Consultation Response from KC, Highways Development Management
2026/91026 38, Highfield Lane, Lepton, Huddersfield, HD8 0NL
Erection of single storey rear extension and conversion of garage to habitable accommodation
Date Responded: 18 June 2026 Responding Officer: Sheila Henley Responding Ref: 11-13/4

Plan ref: 2436 A(10)-01 Proposed Plans.

No.	Date	Dr	Description
scale	As indicated	drawn	PSI
date	MAR 2026	path	G:\Architectural Jobs\2436 - Highfield Lane, Lepton\Arch\Proposed\2436 - proposed\PLANNING.rvt
status			PLANNING
job no	2436	dwg no	A(10)-01
		rev

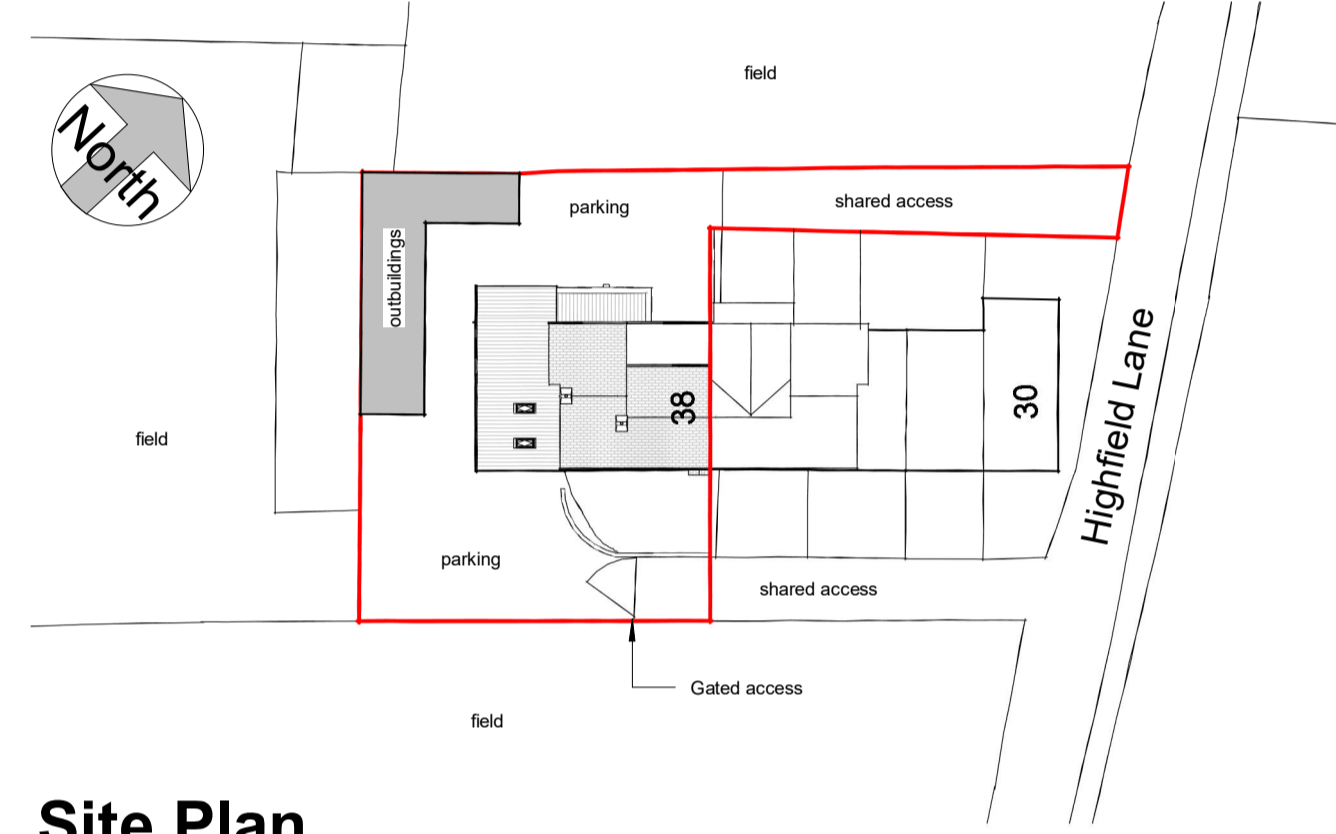
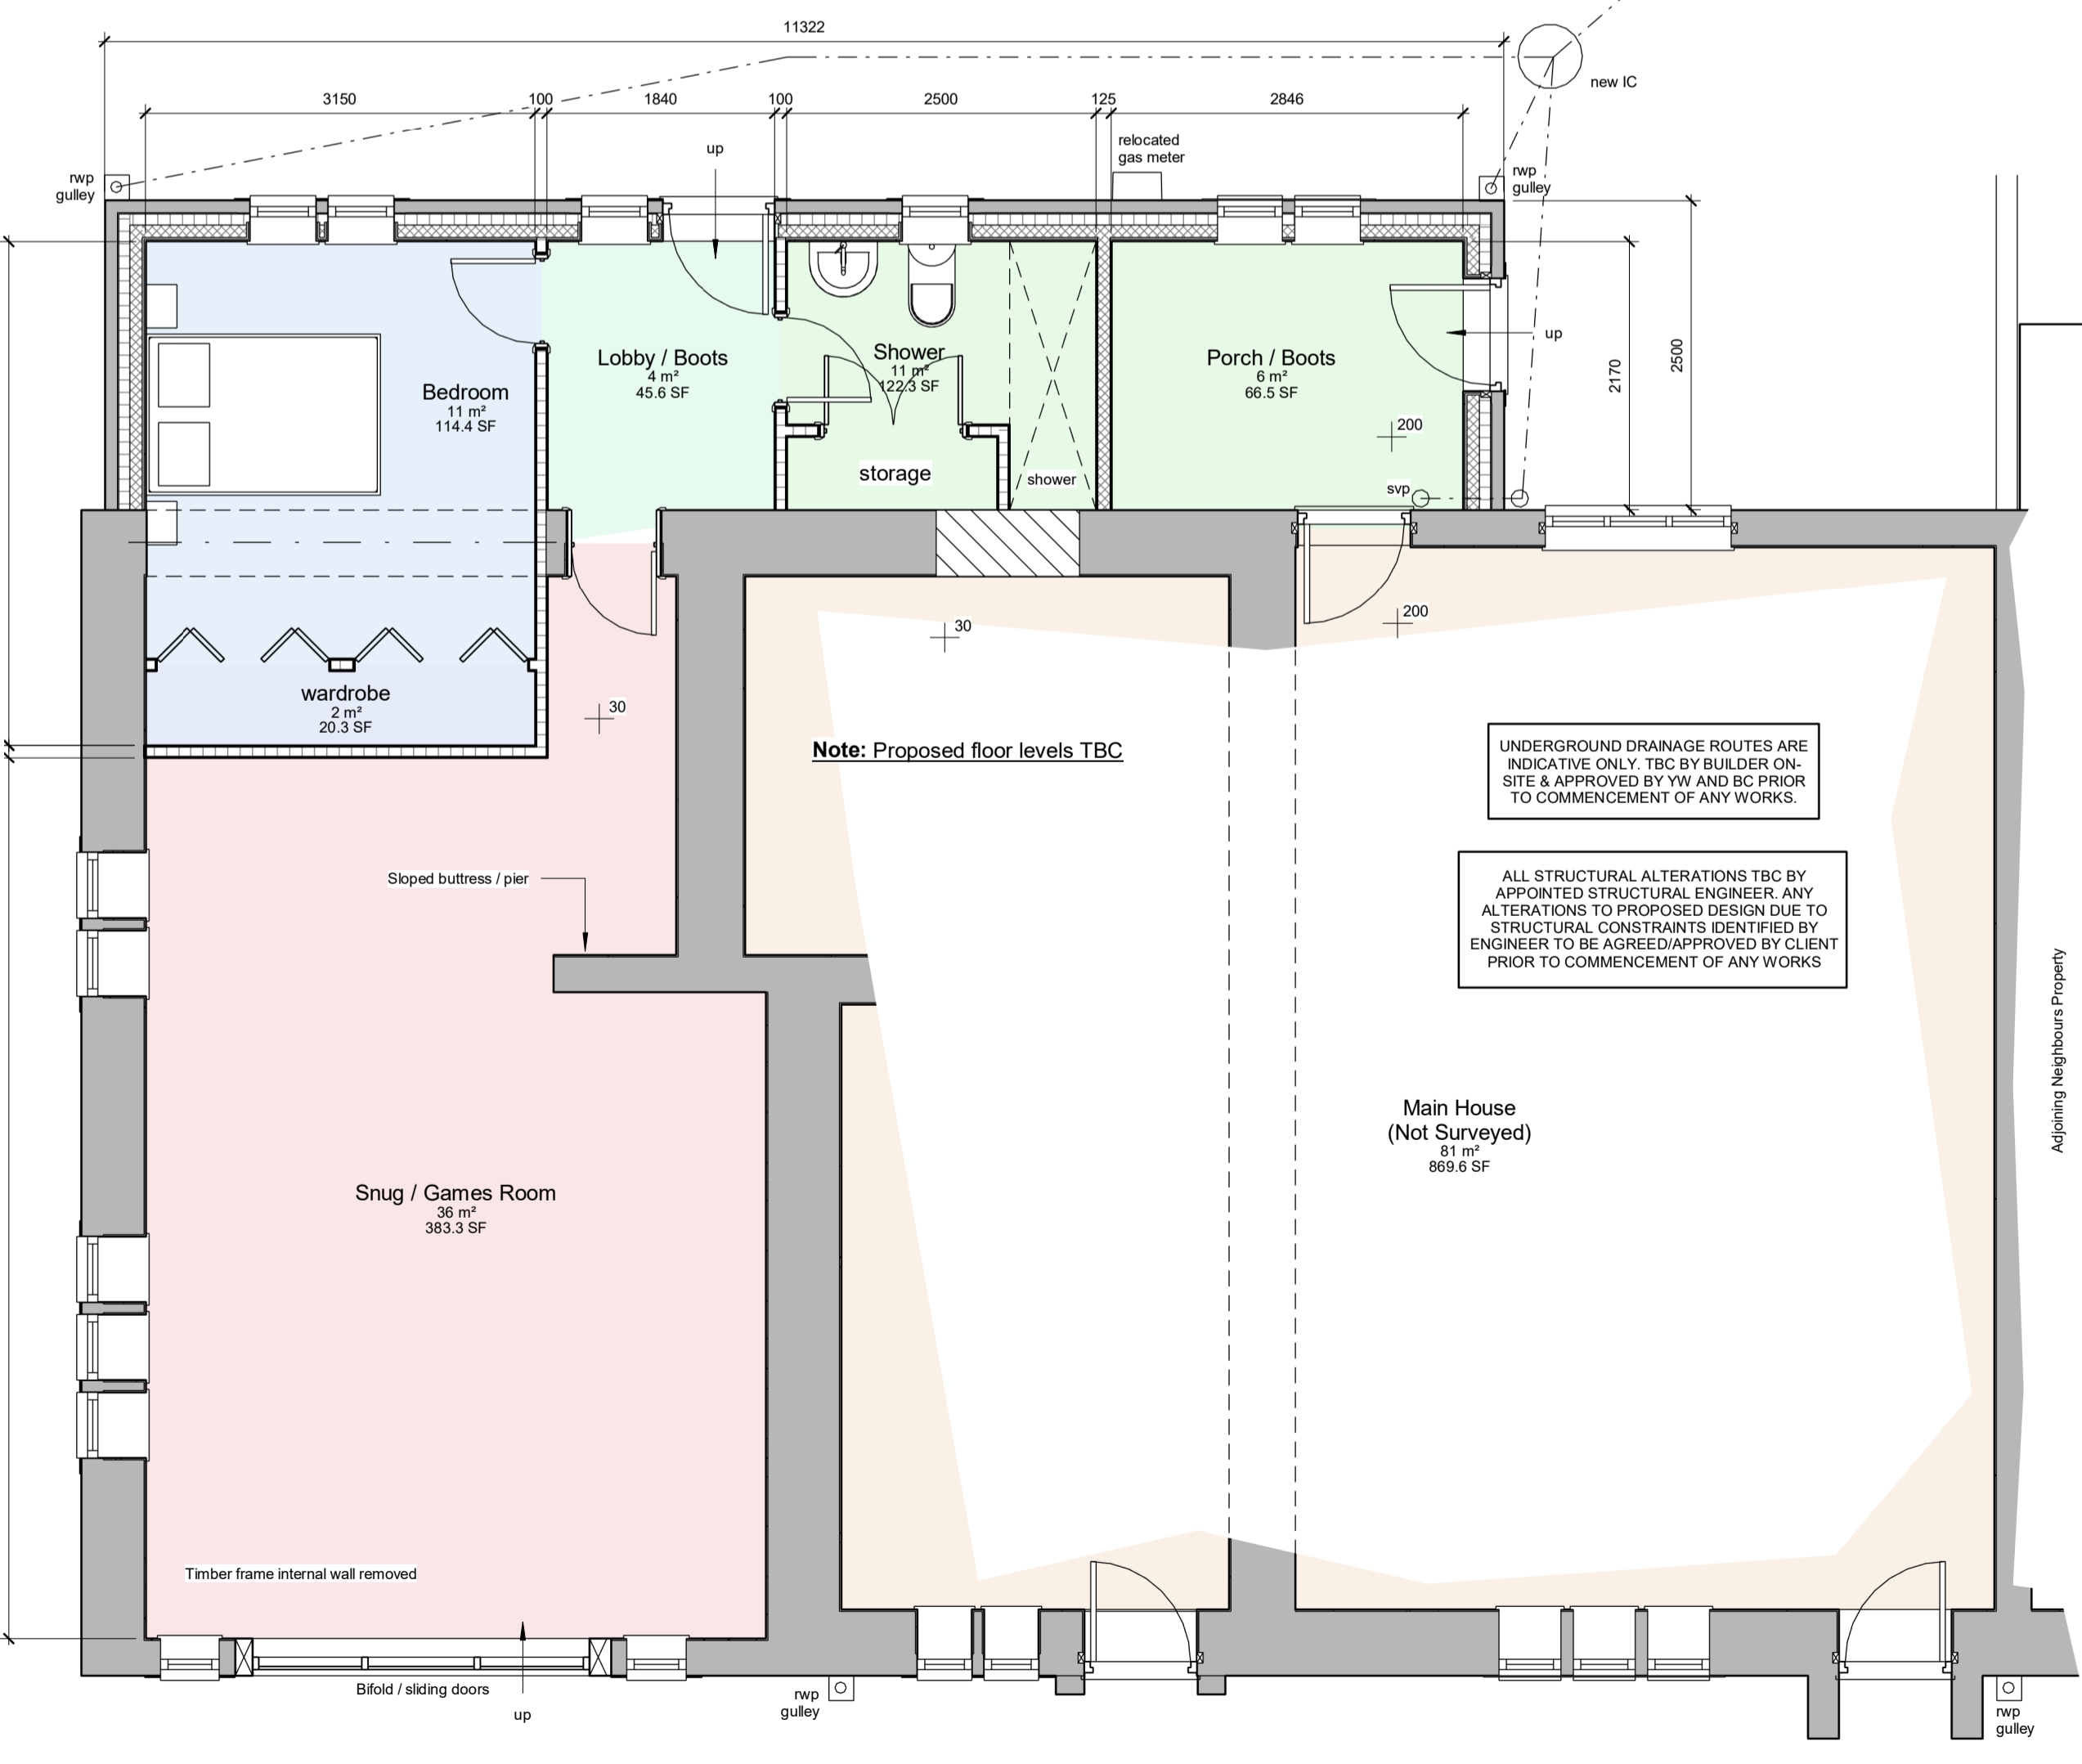
To support policy LP20 and LP22, aid mode choice and Active Travel objectives cycle parking can be provided in the retained storage space on site.

The installation of an electric vehicle charging point is encouraged to help reduce emissions.

The existing access, exterior on-site parking on hardstanding, and turning space are to be retained. There is ample retained hardstanding space to accommodate additional parking associated with the extension given that there is an extra bedroom to be provided and on the loss of the existing garage. The Kirklees Highway Design Guide SPD advising of two spaces for two and three bedroomed dwellings and three spaces and four spaces for four + bedroomed units. The existing space would meet policy LP22 and offers flexibility, including for the provision of visitor parking.
